APPLICATION NO: 3/2012/0660
MOOR HOUSE FARM, CLITHEROE ROAD, KNOWLE GREEN
GRID REFERENCE SD 364691 437974

A planning application has been submitted by Janet Dixon Town Planners Limited on behalf of Mr Roy Brown for the erection of an agricultural building and new septic tank. A site visit was made whilst the applicant and his agent, Mrs Janet Dixon, were present, and the information provided at this meeting, together with the written submissions, forms the basis of this appraisal.

PROPOSED GROUND FLOOR PLAN

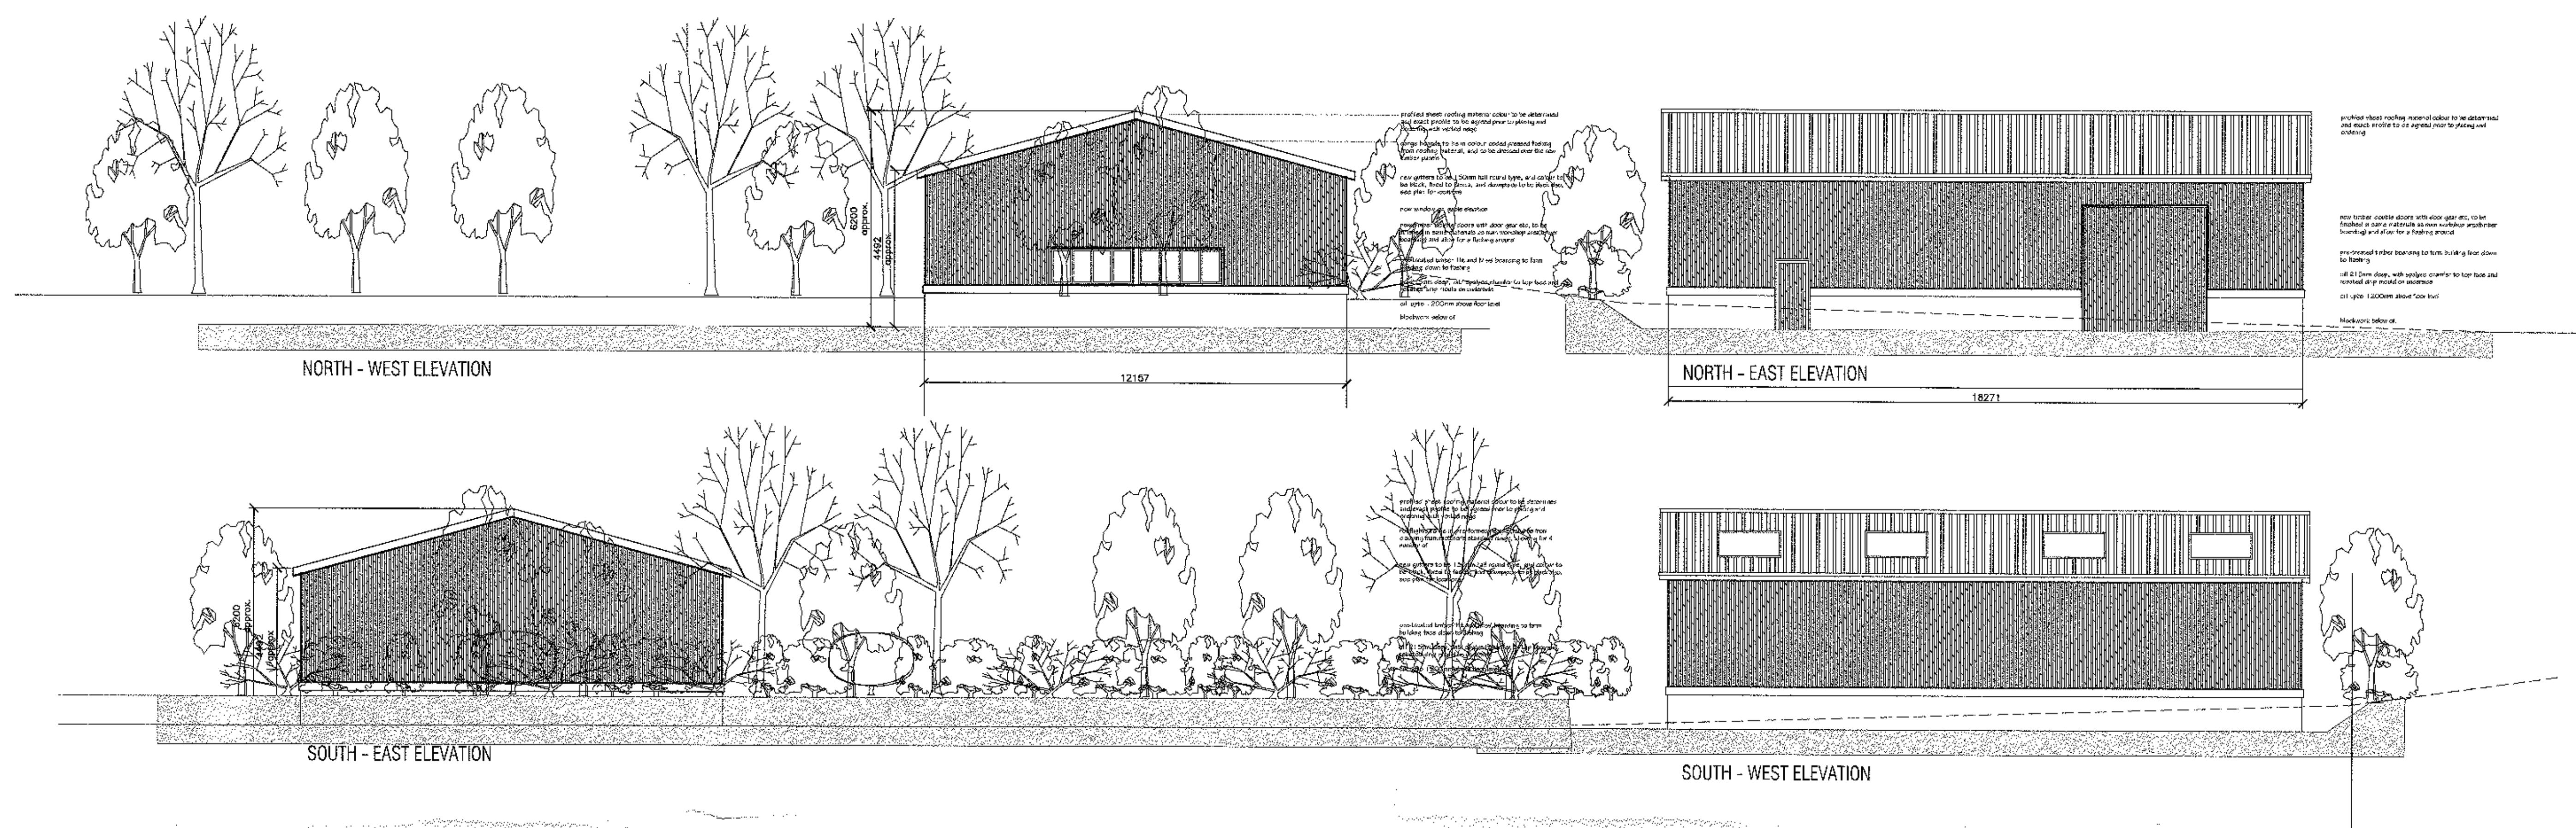
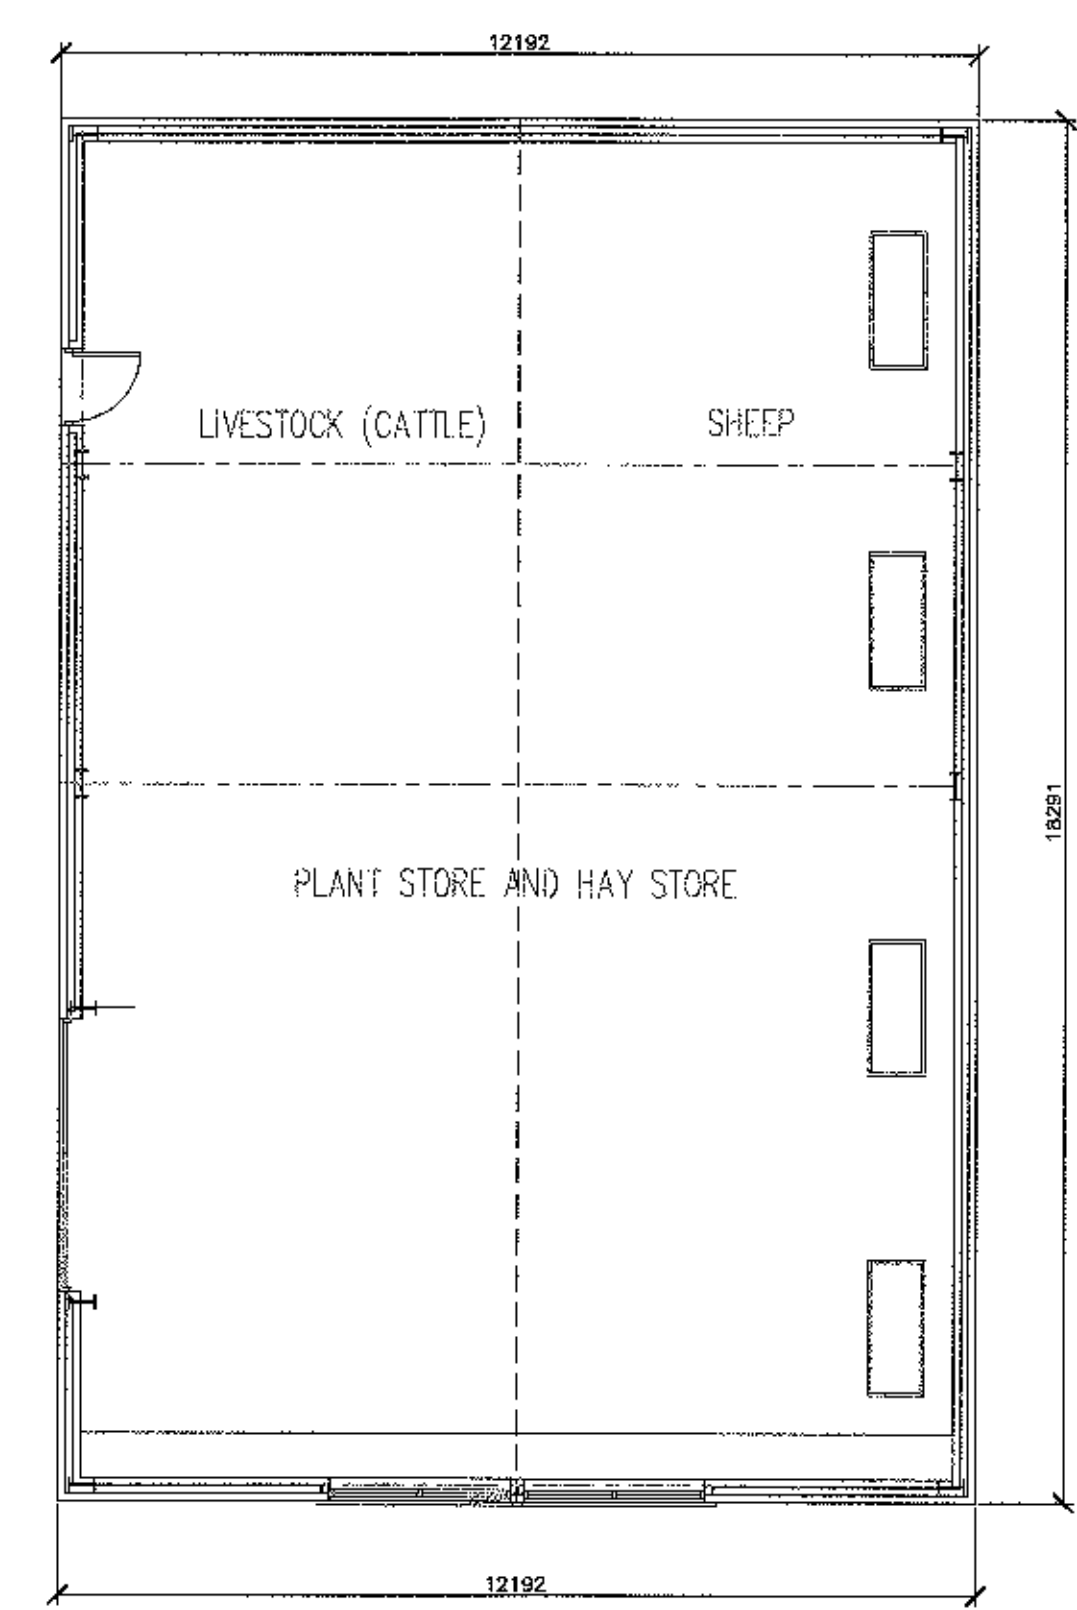
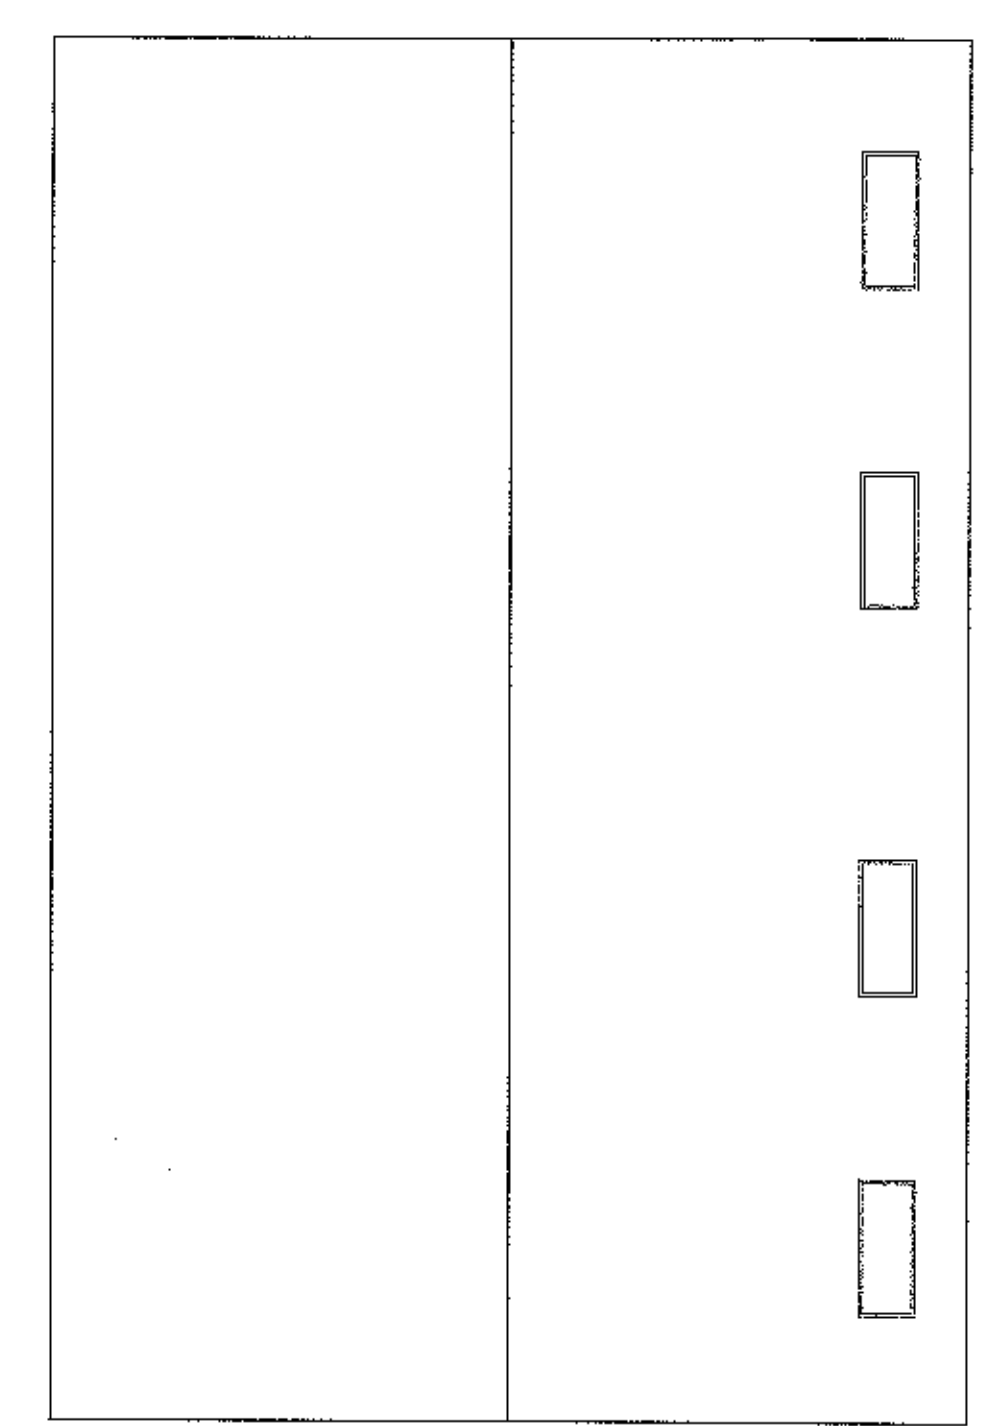
Whilst a facility may be required, I am of the opinion that the proposed building is not suitable for the intended purposes. There are a number of errors in the proposed design in terms of using the building for the intended purposes. These include: inadequate access for and to the livestock; inadequate feed areas for livestock; and no scraping passage/waste handling facilities for livestock. For example, the building inspected at the neighbouring farm, where I was told the cattle are currently kept, consisted of an open fronted elevation with an overhang and feed face.

The provision of stone cladding to the concrete block walling is not necessary, and in my opinion the height of the concrete block walling could be further increased. The walls should be single skin and a maximum eaves height of 4m would be suitable. Metal sheeting to the roof can sometimes be subject to corrosion due to condensation, and fibre cement sheeting is more commonly used. The presence of windows in the gable end is not an agricultural requirement, with natural light normally provided by way of roof lights into the building. An open fronted facility would also assist in this regard.
